Engineers Comments Regarding Surface Water Drainage and Flood Risk

APPLICATION **EG/16/19/HH**

Site Address: 49 Warren Way Barnham PO22 0JX

Description of Works: Two storey extension

Site & Block Plan

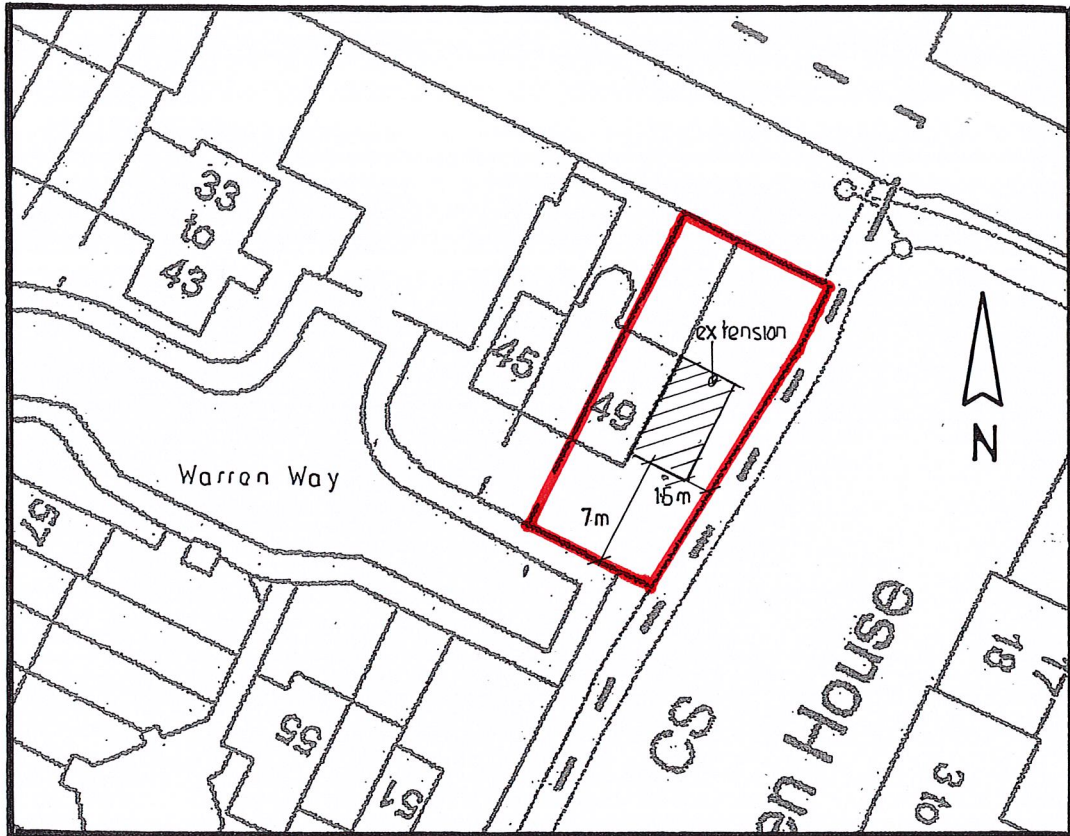
The application is within Flood zone 3. The Environment Agency should be consulted. Please note the application is close to a main river, the Environment Agency usually require 8m clearance between the top of bank of main river and any proposed structure.

Figure 5 Environment Agency's Surface Water Flood Risk Map

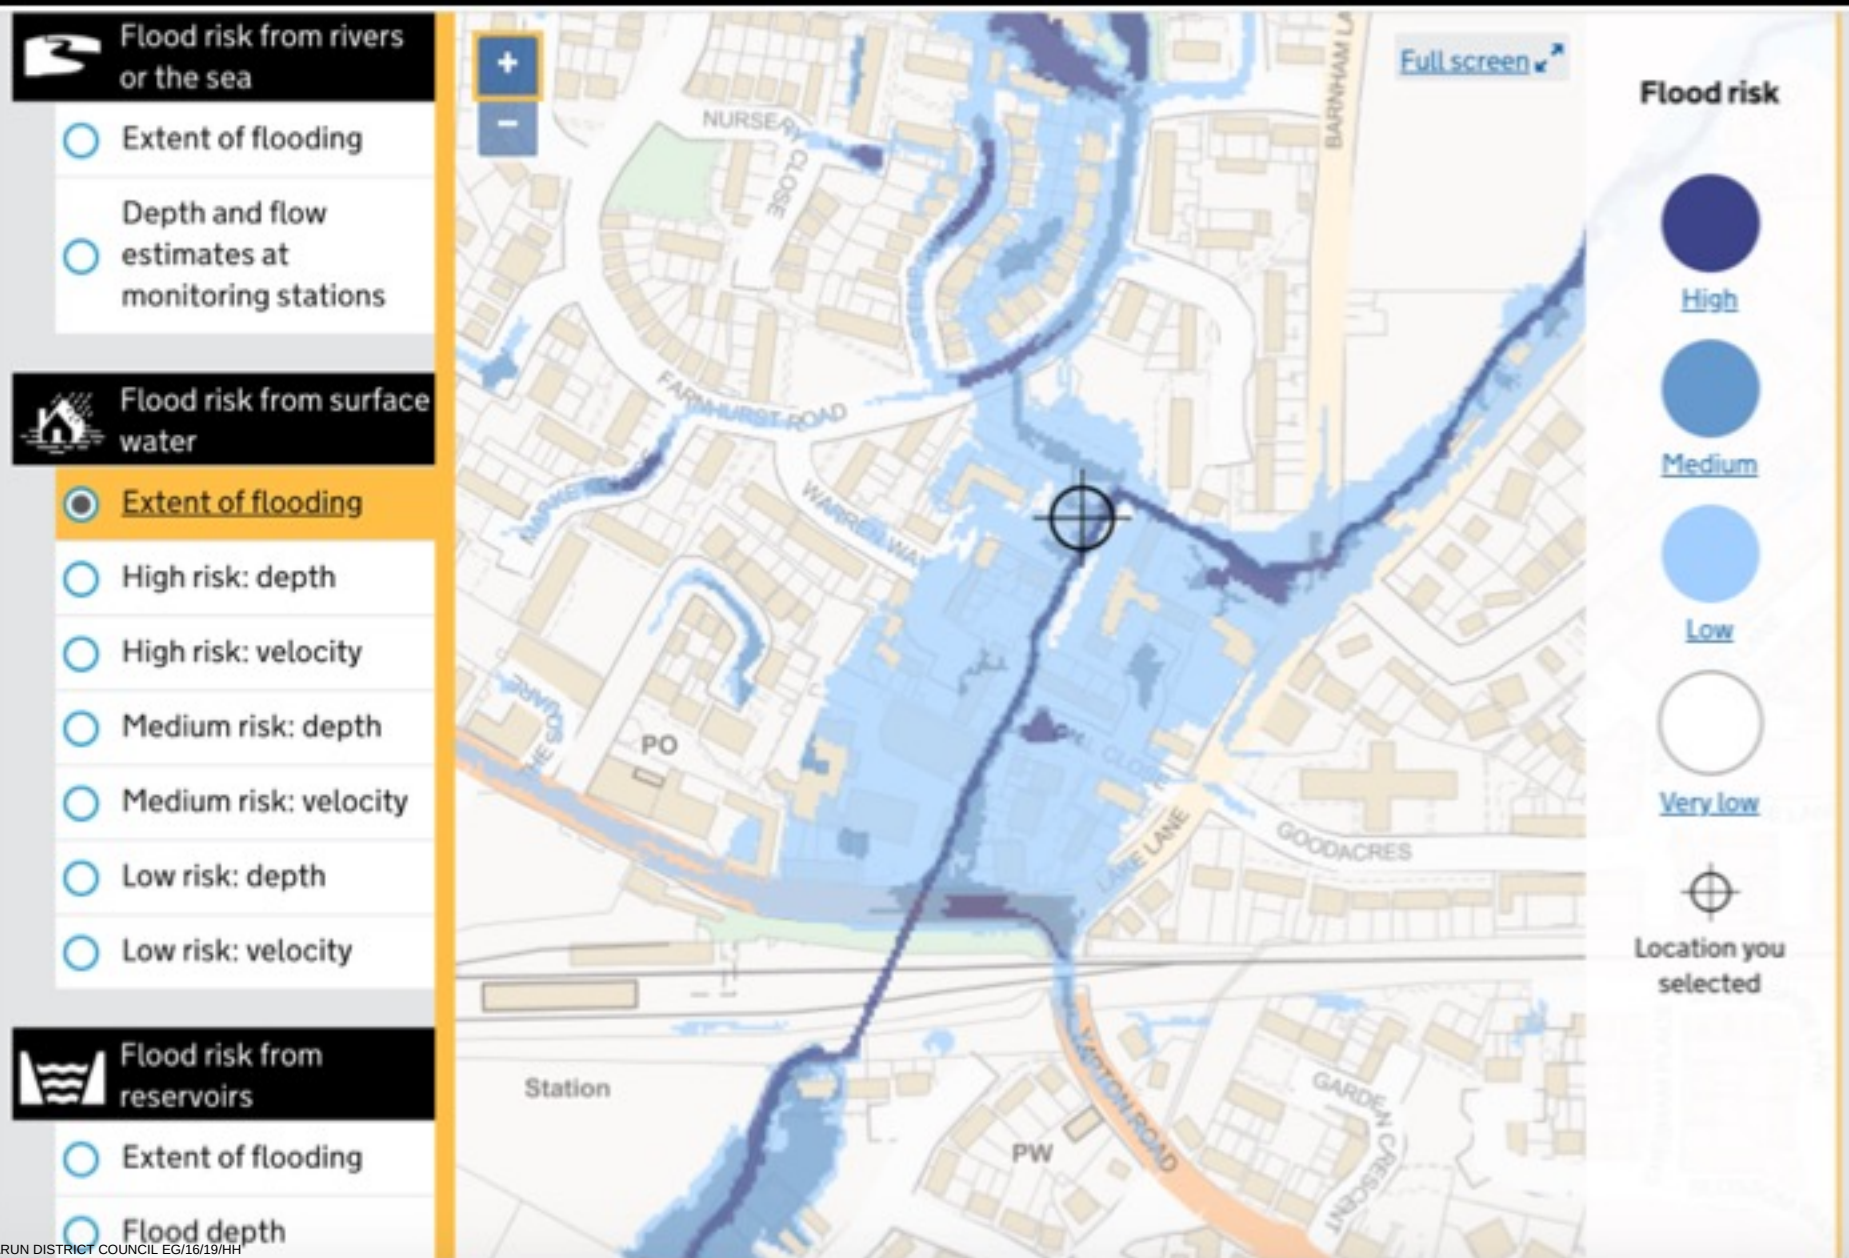
It should also be noted that the application is also within an area at risk from surface water flooding. We would encourage the use of flood resilient design.
